## NSW RURAL FIRE SERVICE

Your reference: SSD 8859  
Our reference: DA-2019-00324-Response to  
Submissions-1

Date: Wednesday 8 September 2021

**State Significant Development – Highway Service Centre  
Request for comments – exhibited Environmental Impact Statement (EIS)  
1111 ELIZABETH DR CECIL PARK NSW 2178, 2/4/DP2954**

TITLE
STRUCTURE PLAN **DA06**
DRAWN BY: SB CHECKED BY: RD DATE: 03/08/2020 ISSUE: AI

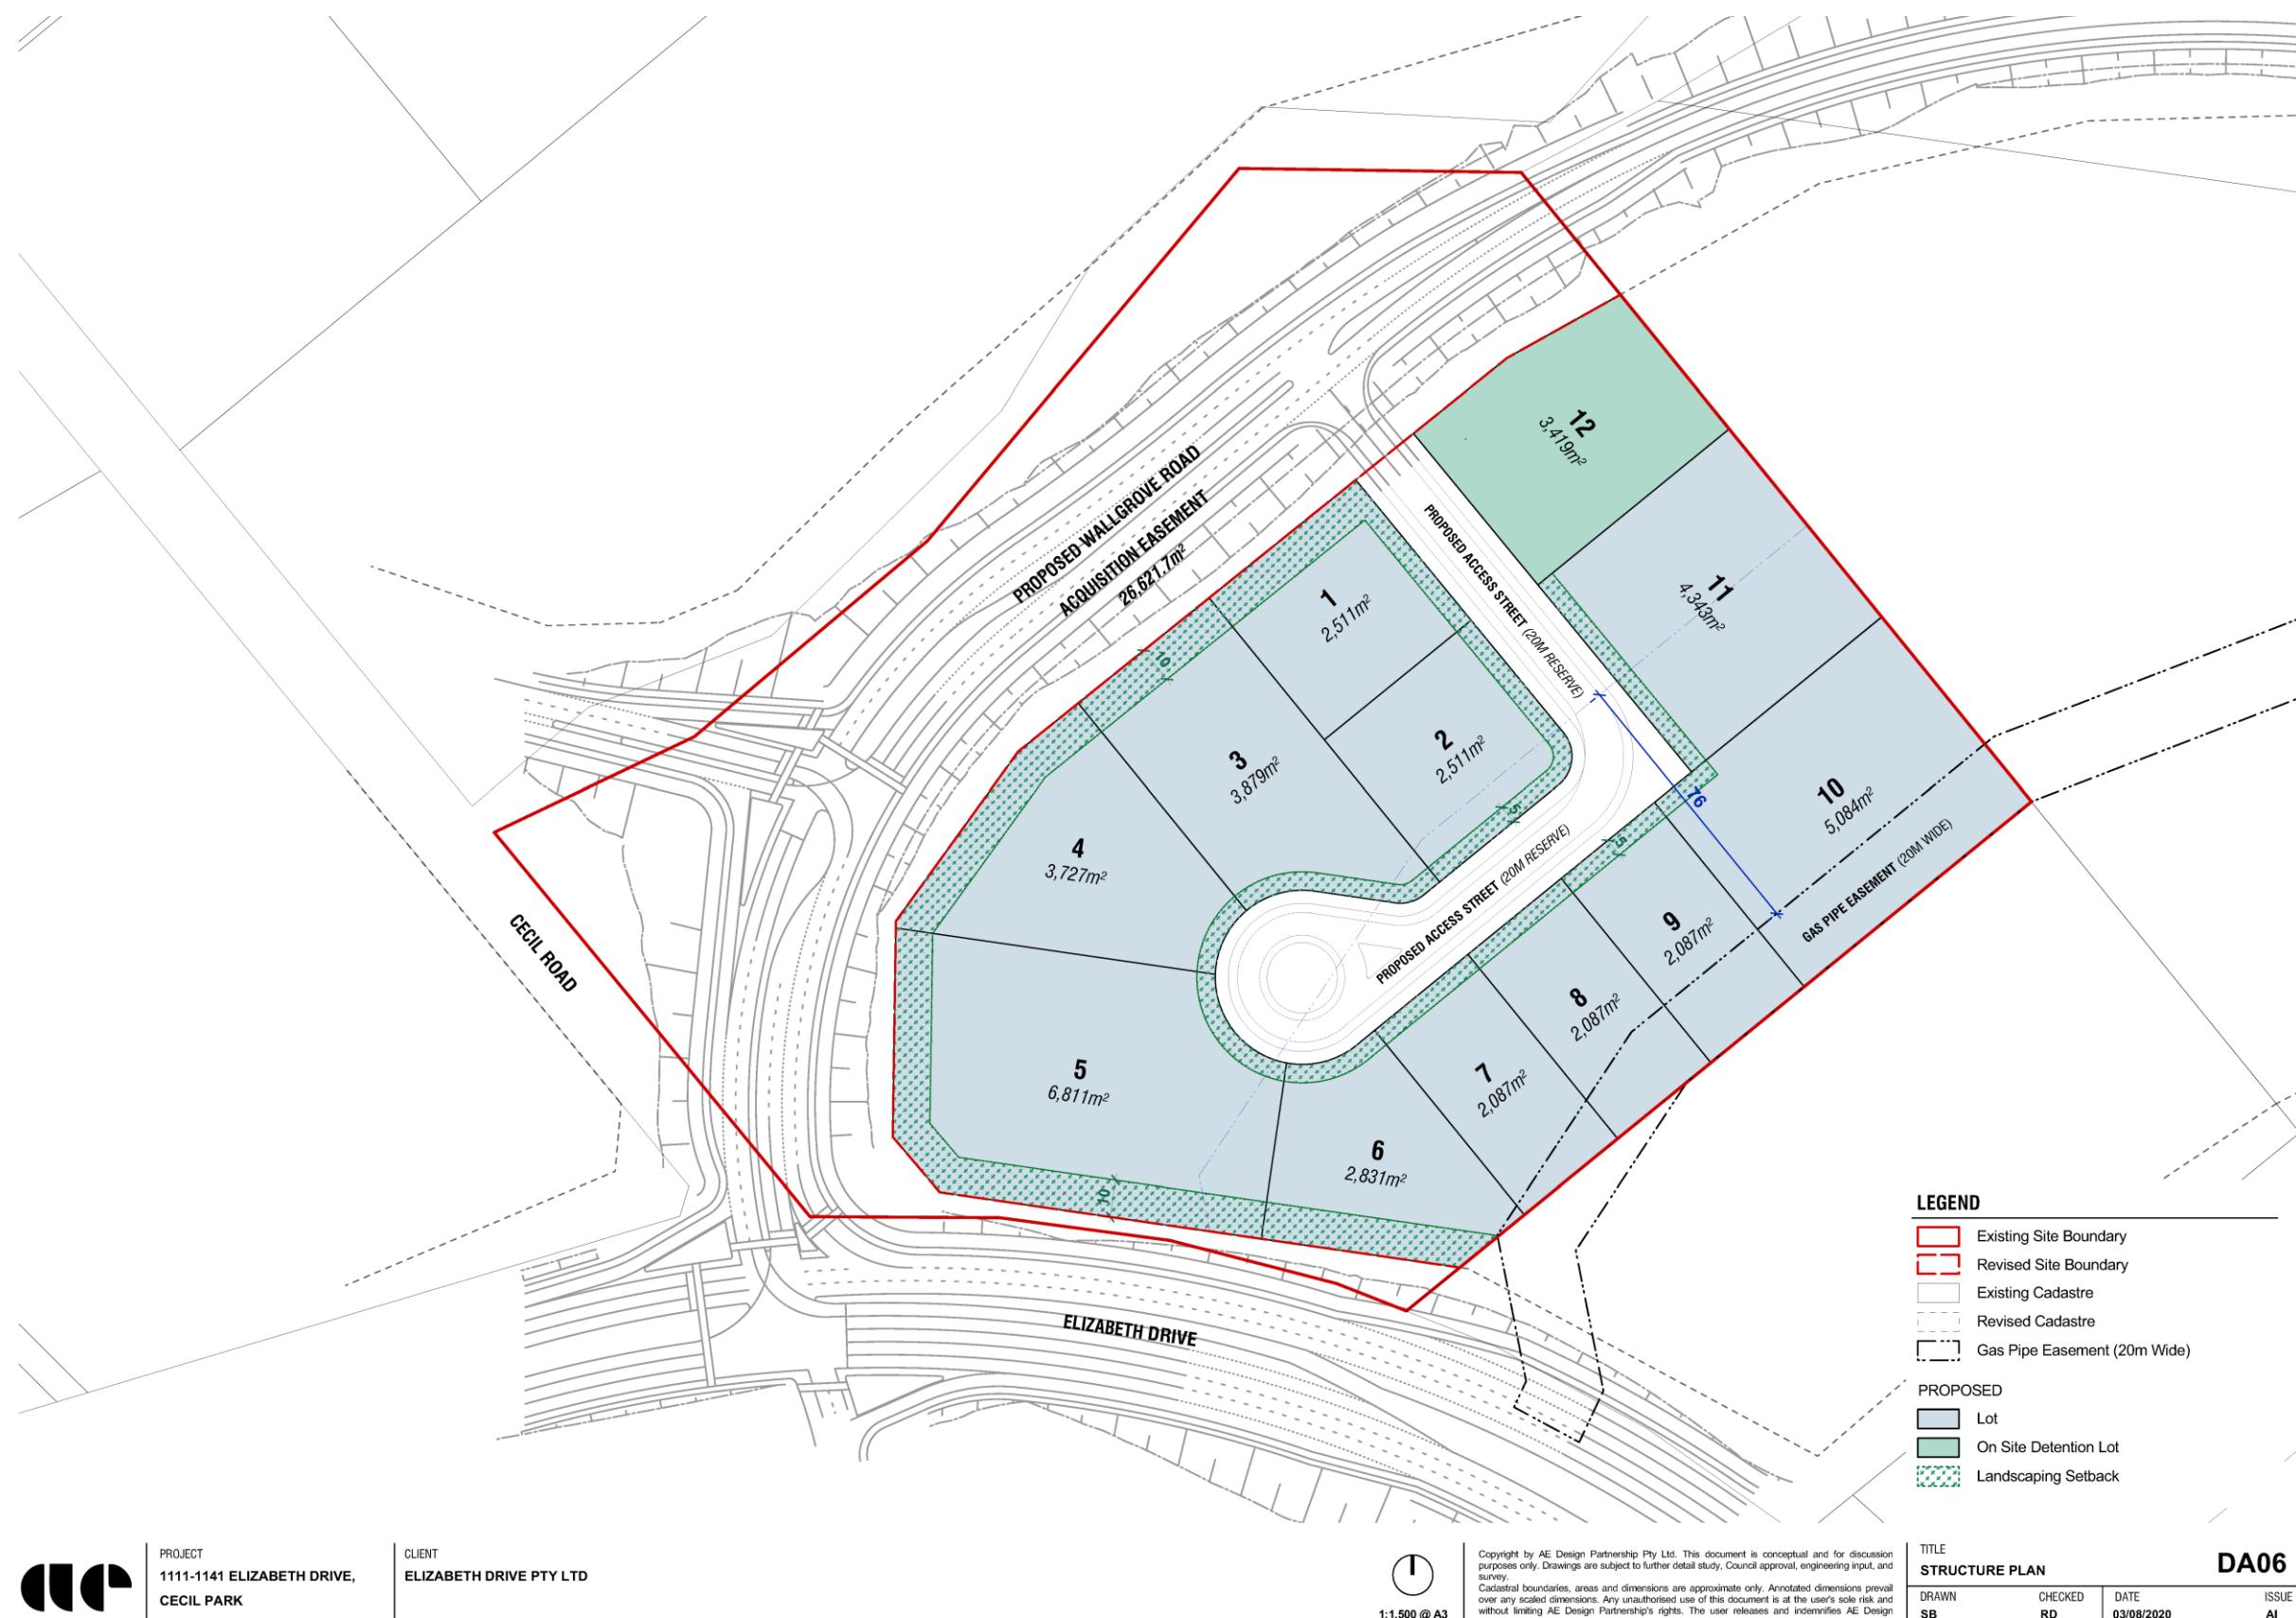
2. Prior to the issue of subdivision certificate, the widening and realignment of Elizabeth Drive and Wallgrove Road to which the proposed development relies upon for the purposes of an Asset Protection Zone (APZ), must be constructed to the extent as depicted on the 'structure plan' prepared by AE Design Partnership Pty Ltd, dwg no. DA06, issue AI, dated 14/08/2020.

Figure 4-2 Proposed Subdivision Plan DA05
AE design Partnership (August 2020)

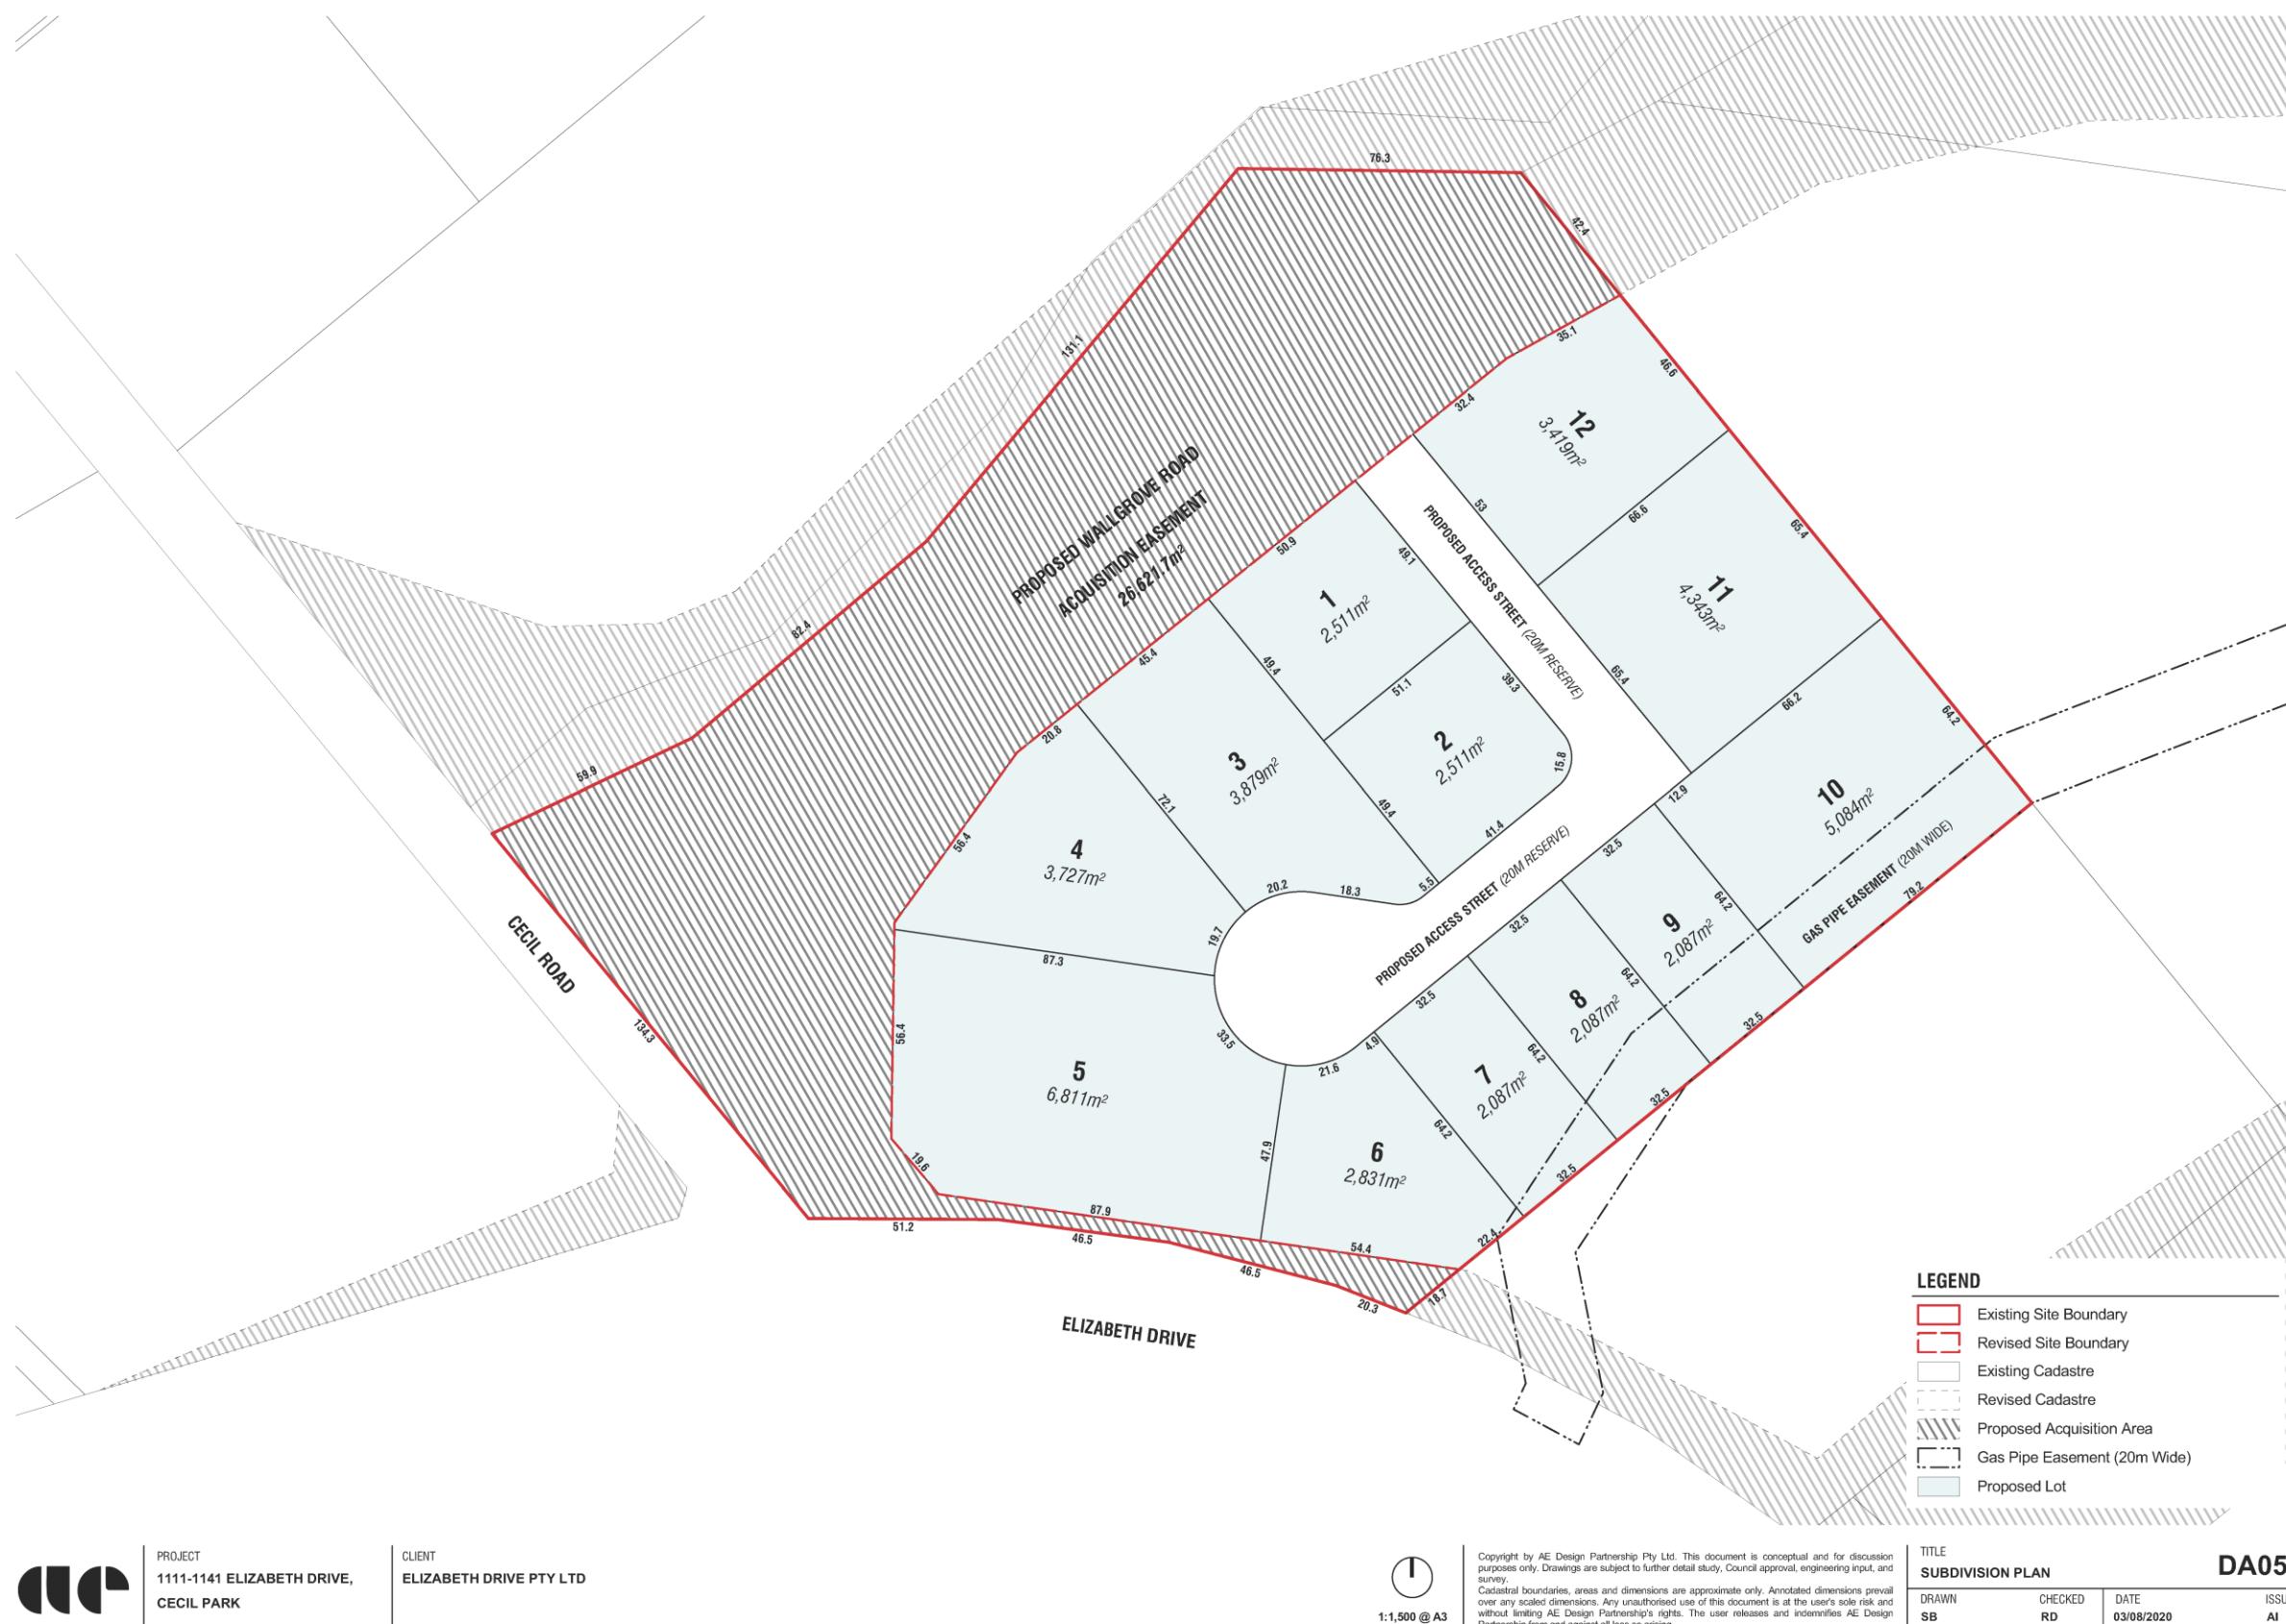
1. Prior to the issue of subdivision certificate, a restriction on the use of land must be created under section 88B of the *Conveyancing Act 1919* in the following manner on proposed lots 6 to 12 (as denoted in the 'Subdivision Plan' prepared by AE Design Partnership Pty Ltd, dwg no. DA05, issue AI, dated 14/08/2020):

- For the entirety of lots 6 to 12, to prohibit 'hazardous industries' (including service stations) as defined under section 8.3.9 of *Planning for Bush Fire Protection 2019*, 'special fire protection purposes' as defined under section 100B(6) the Rural Fires Act 1997, and other Class 9 buildings (with a floor space area great than 500m<sup>2</sup>) per section 8.3.11 of *Planning for Bush Fire Protection 2019*; and
- To prohibit the construction of buildings (other than class 10b structures) within 20 metres of the north-eastern boundary of lots 10 to 12; and
- To prohibit the construction of buildings (other than class 10b structures) within 16 metres of the south-eastern boundary of lots 6 to 10.
